Reference No:	2024/62/93564/W
Site Address:	20, Rowley Drive, Lepton, Huddersfield, HD8 0AH
Description:	Erection of single storey rear extension, front porch, dormers, demolition of garden buildings including hip to gable alteration to existing roof and associated alterations.
Recommending Officer:	Joshua Merriman

HOUSEHOLDER DELEGATED REPORT

Application Number	2024/93564
Location	20, Rowley Drive, Lepton, Huddersfield, HD8 0AH.
Proposal	Erection of single storey rear extension, front porch, dormers, demolition of garden buildings including hip to gable alteration to existing roof and associated alterations.
Publicity end date	20/02/2025
Number of representations received	None.
Kirklees Local Plan Allocation/Designation	The application site is located in a bat alert layer but is otherwise unallocated in the Kirklees Local Plan.
Extension to Time (EoT)	No
Recommendation	Conditional Full Permission

REPACEMENT GARDEN BUILDING PROPOSED PLANS & ELEVATIONS @ 1:50

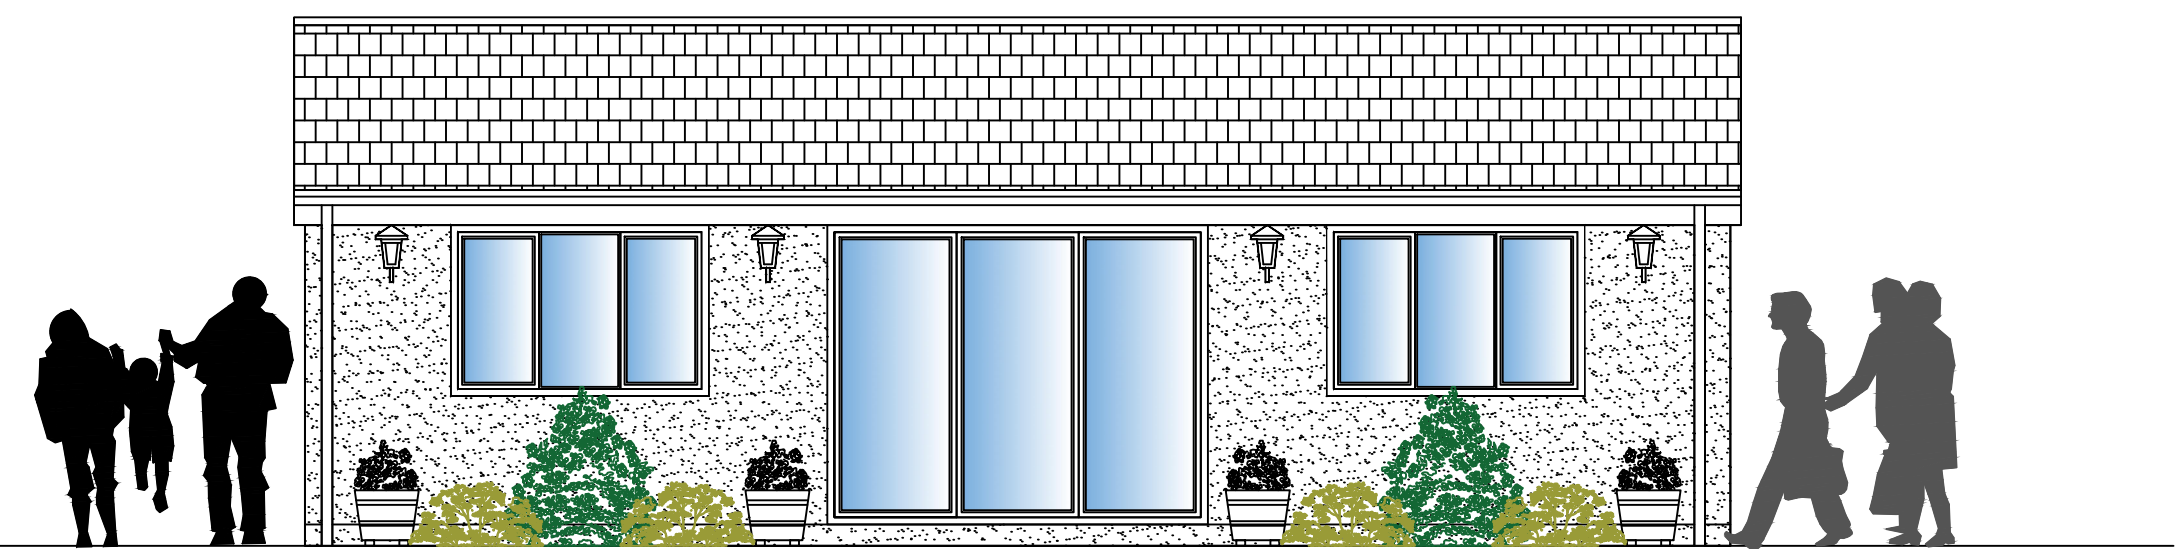
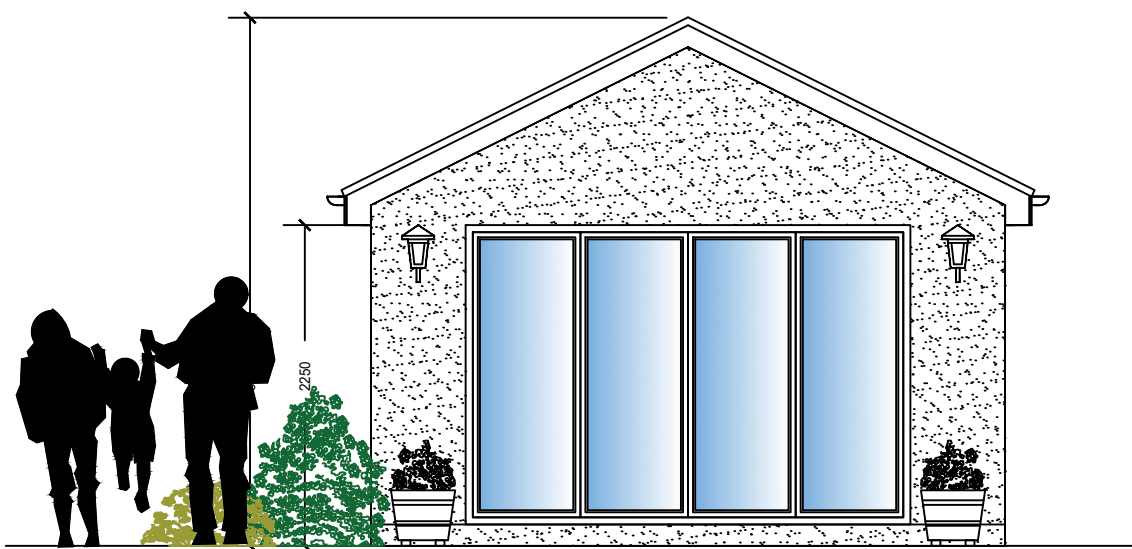
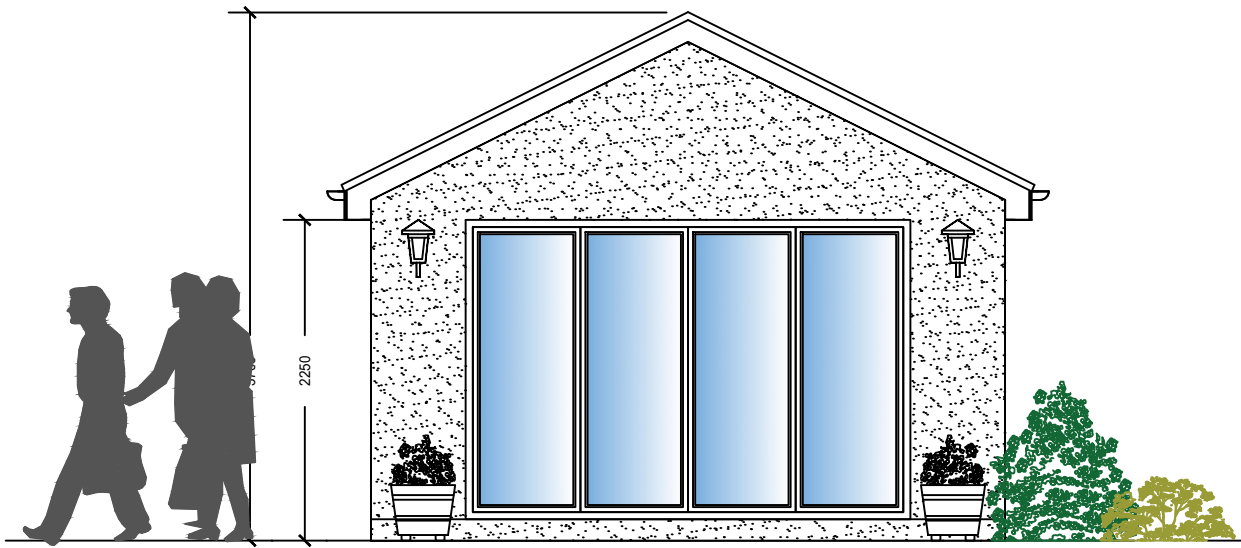
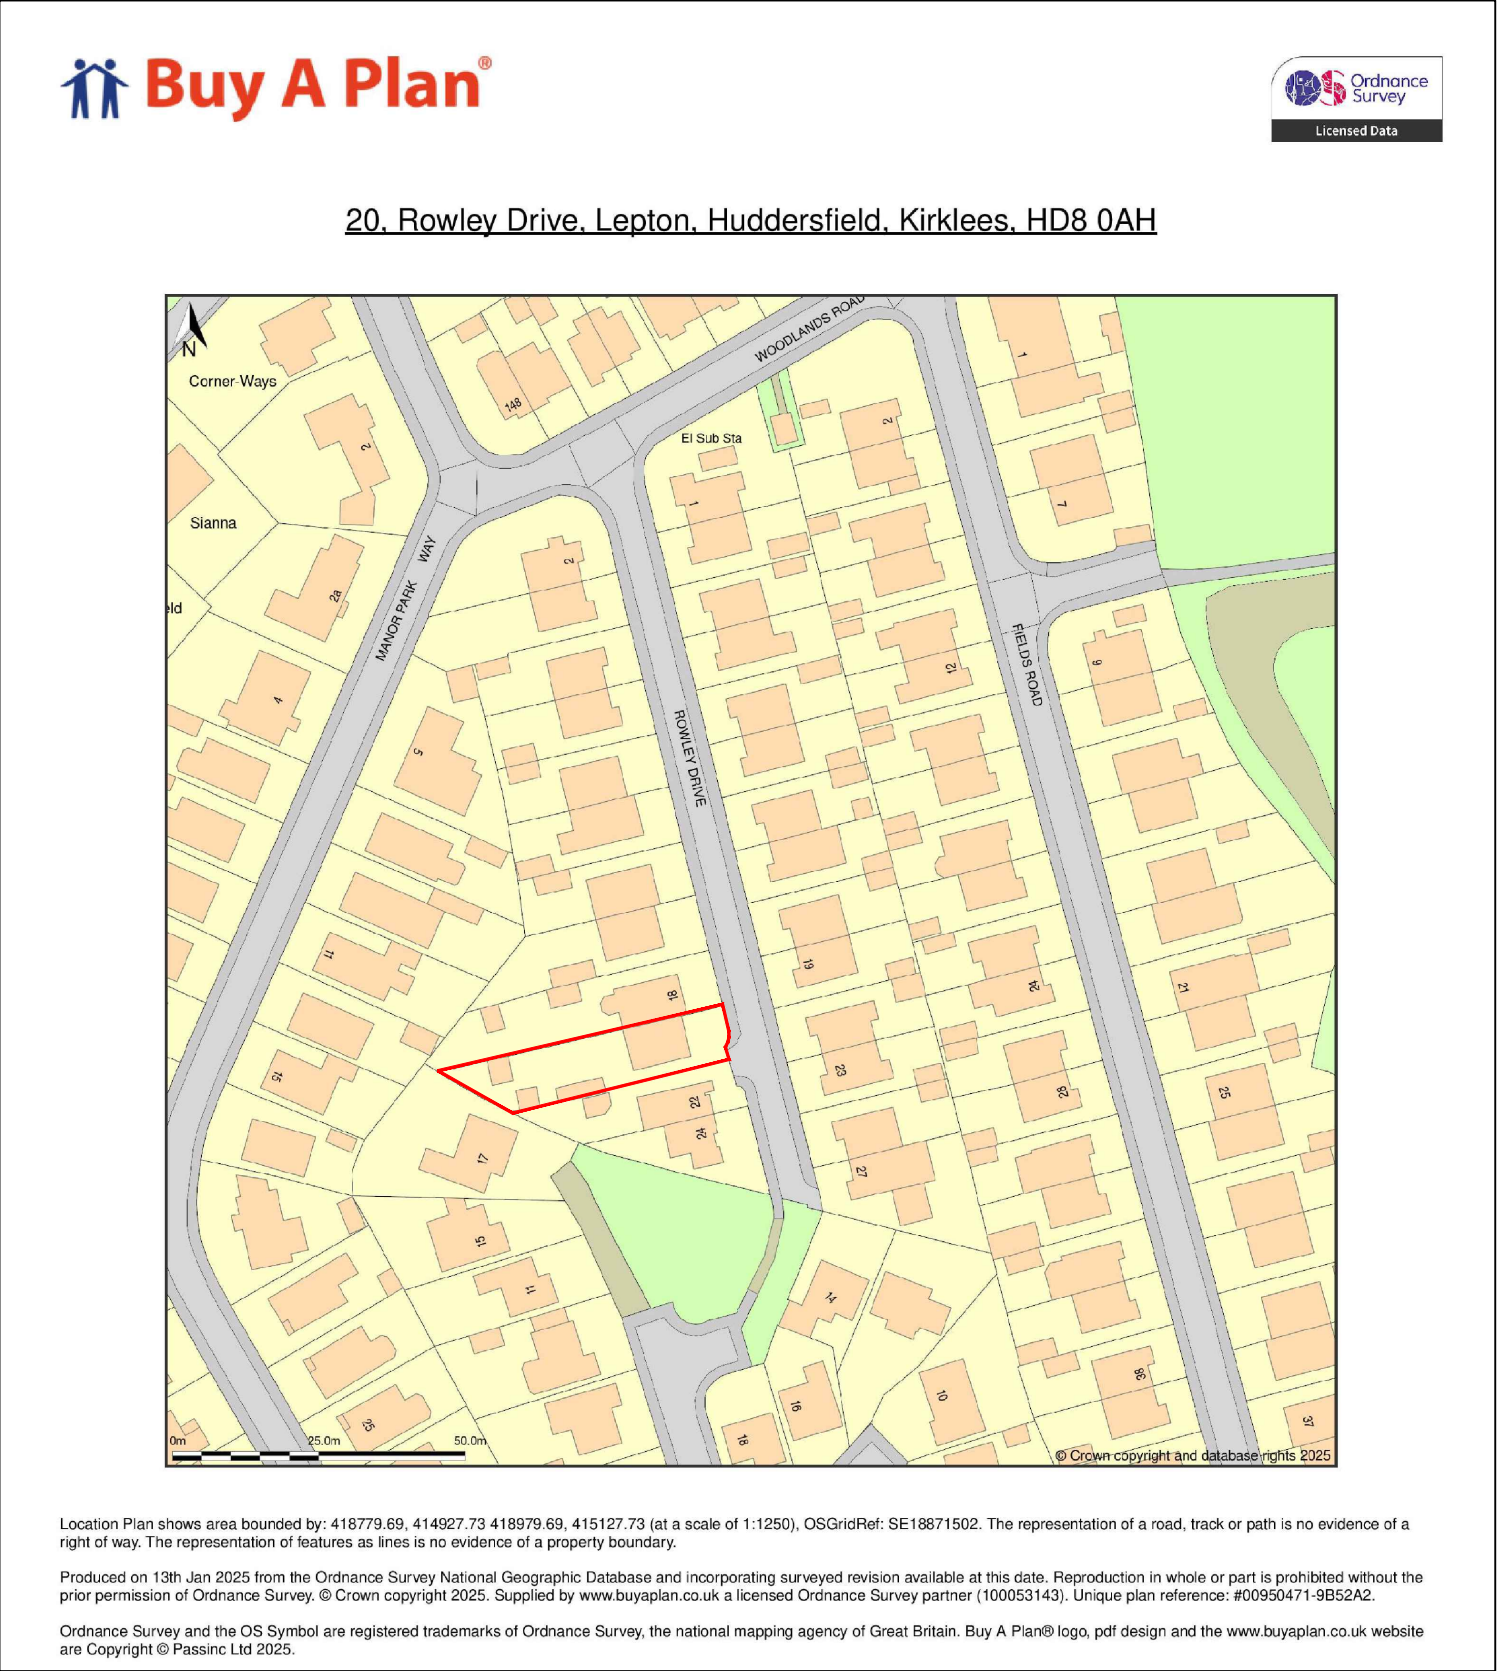
Negotiations/Amendments during course of application	Yes	During the course of the application, officers requested that the proposed outbuilding was removed from the proposals due to concerns regarding its resultant impact upon the residential amenity of the neighbouring occupants. An amended plan was received on this basis.
Parish/Town Council comments sought	No	
Planning History	No	
Consultations required	No

PROPOSED PLANS & ELEVATIONS @ 1:100

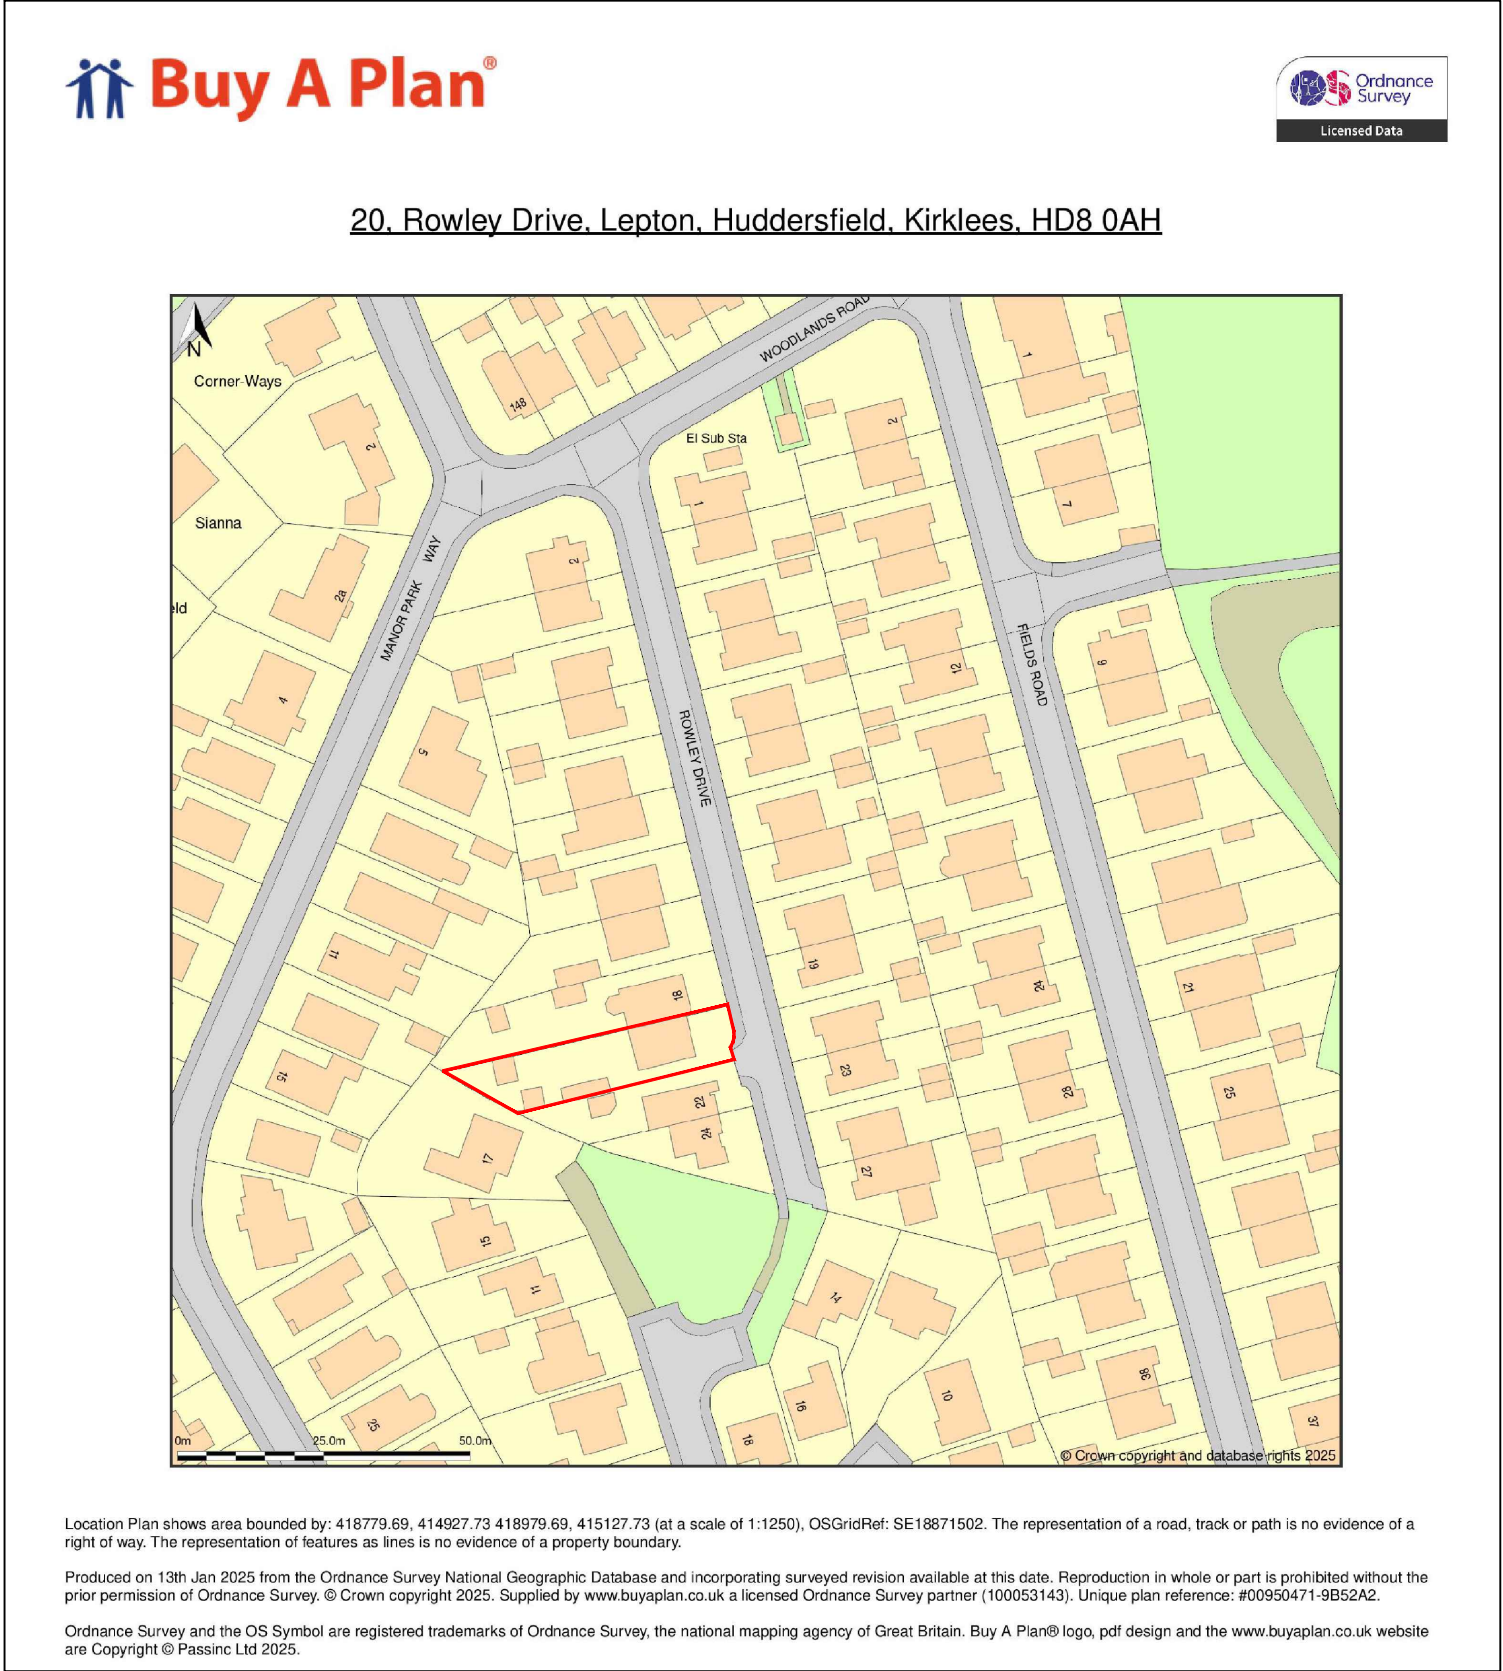
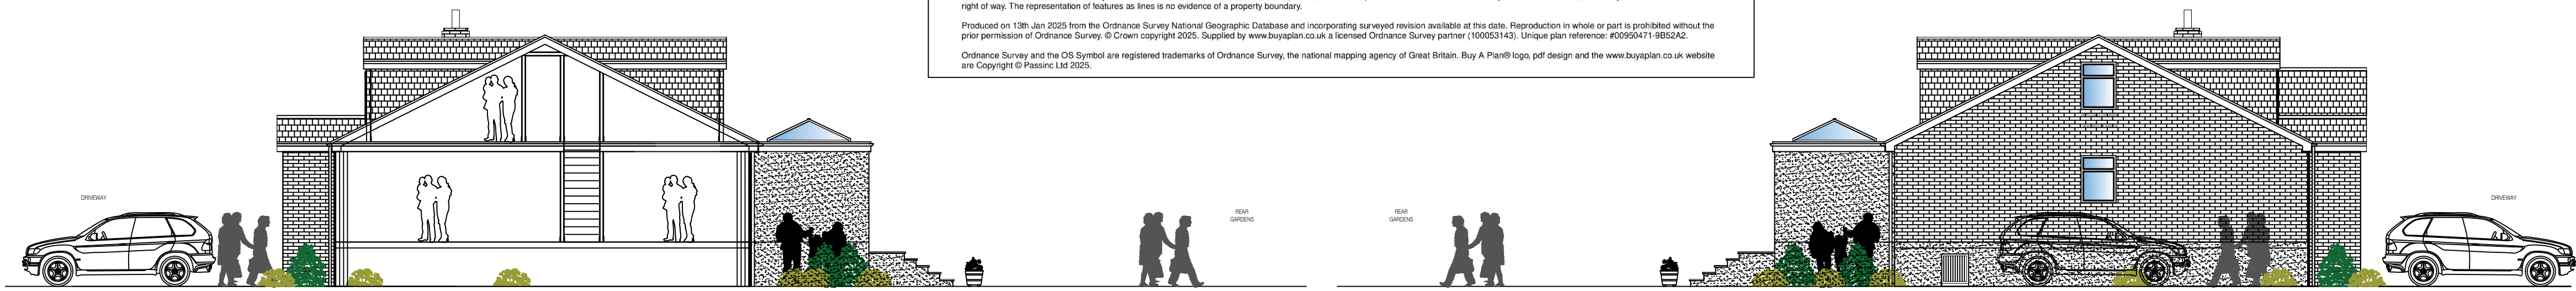
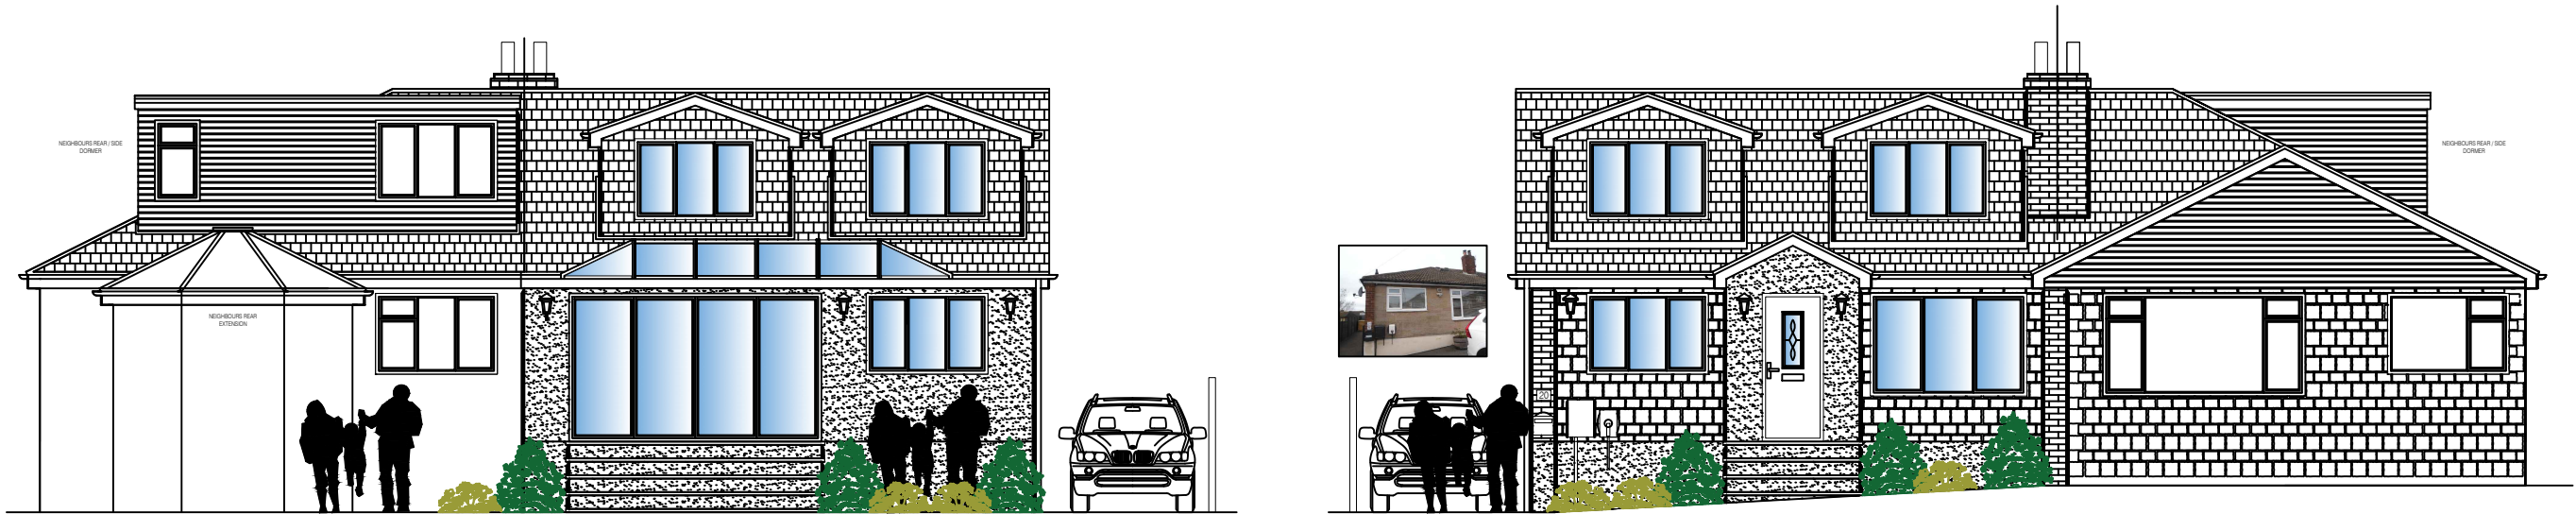
not exceed 4 metres in height	The maximum height of the proposed rear extension is 3.67m, not exceeding 4m.	
not project out more than 3 metres from the rear wall of the original house for semidetached and terraces houses or by 4 metres for detached properties		The extension will project 3.04m which is greater than the guideline 3m for semidetached properties, however, this is considered to be an insignificant breach

that will have no material impacts on neighbouring dwellings and is therefore considered acceptable.
where they exceed 3m in length the eaves height should generally not exceed 2.5 meters		The eaves height of the extension is 3.42m where it exceeds 3m in length, however, due to the proposal only minimally breaching 3m in height, this is again considered to be an insignificant breach and acceptable.
retain a gap of at least 1 metre from a property boundary, such as a wall, fence or hedge		A gap of only 0.56m is retained to the property boundary, however, there would still be no breach of the 45-degree rule from the centre sill of the closest neighbouring window, therefore, as there are no significant impacts as a result of this it can be considered acceptable.
Single storey front extensions permitted where:	<u>Yes - COMPLY</u>	<u>No - JUSTIFY</u>
The house is set well back from the pavement or is well screened	The house is well set back from the pavement, by approximately 7m.
